Planning Application Reference: CM/26/22/DOC

Proposal: Approval of details reserved by condition imposed under CM/70/21/PL relating to conditions 3-Construction Management Plan, 5-Landscape Scheme, 15-renewable energy or low carbon energy sources and 17-schedule of materials and finishes.

Location: Wren Cottage Horsemere Green Lane Climping BN17 5QZ

Condition 3 – Construction Management Plan

Drawing No.
6099-WLA-XX-ZZ-DR-A-0002

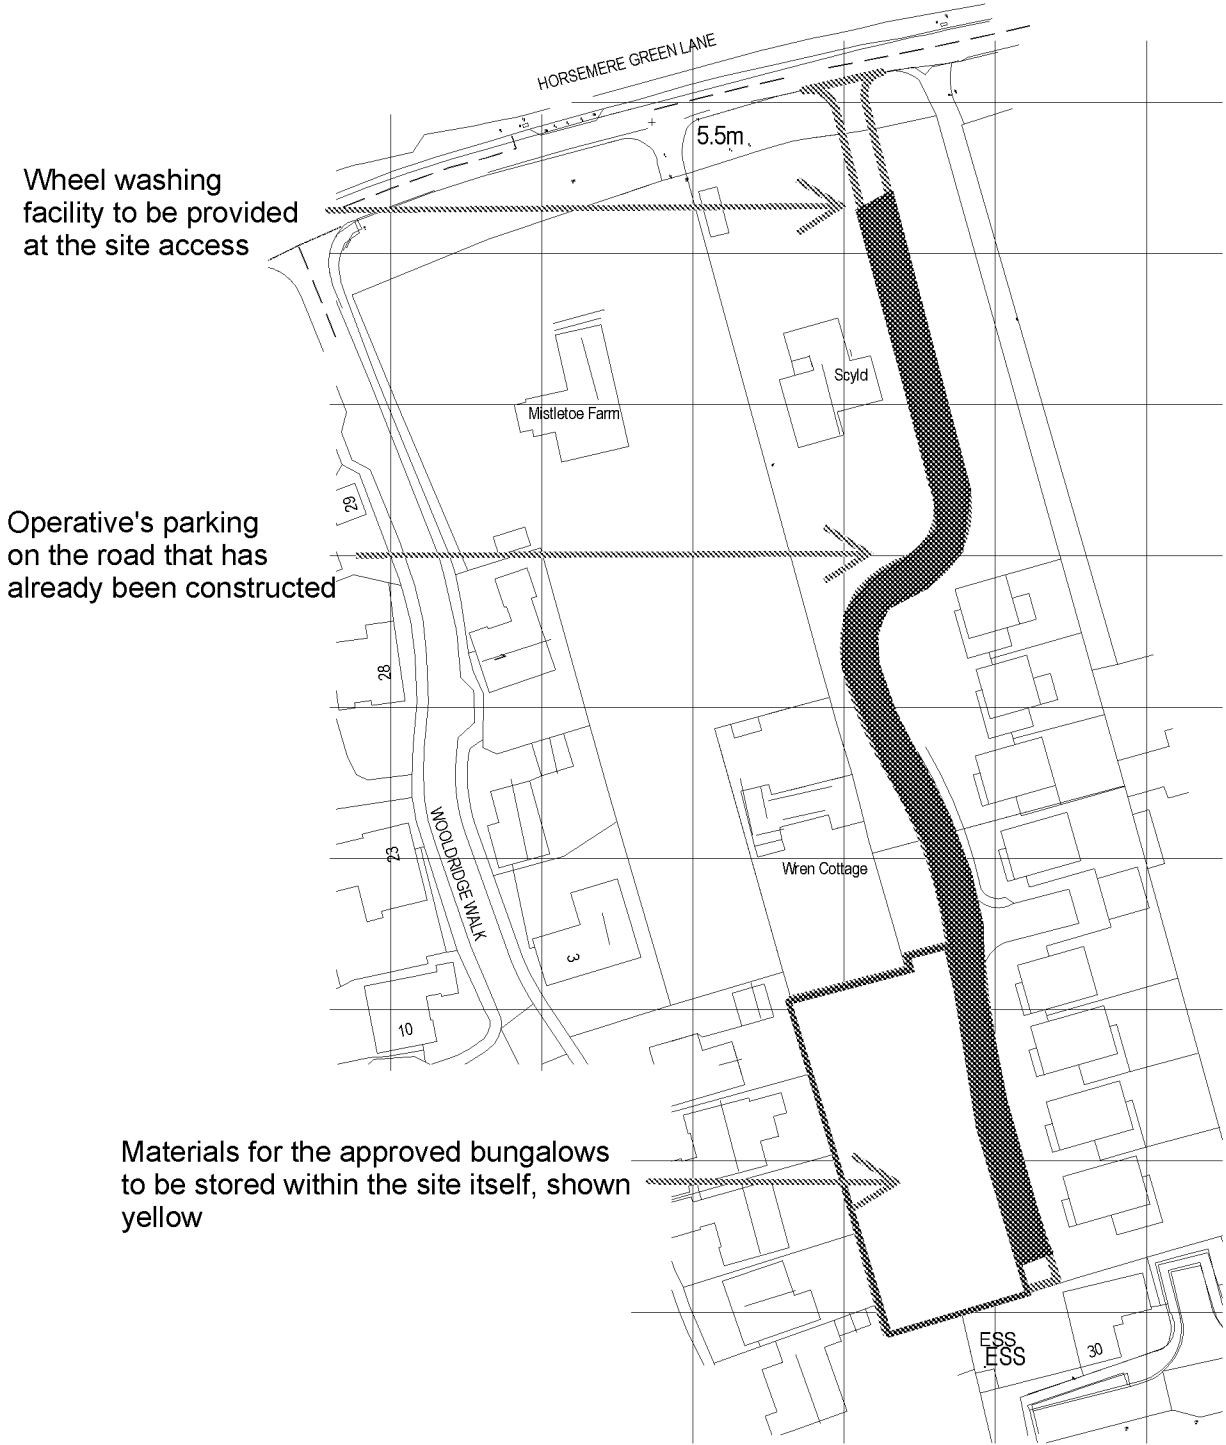
Dear Mr Holmes,
In respect of the CMP details please provide a site map detailing locations for parking, storage of plant and materials, access roads /routes on site and the provision of wheel wash facilities. I would appreciate receipt within the next 10 days.

Sorry for the delay in responding to you.
The information is satisfactory and I recommend the condition may be discharged,

Please see the plan attached on which the locations for operatives parking, storage of materials and wheel washing facilities have been marked. If you require any further information please let me know.
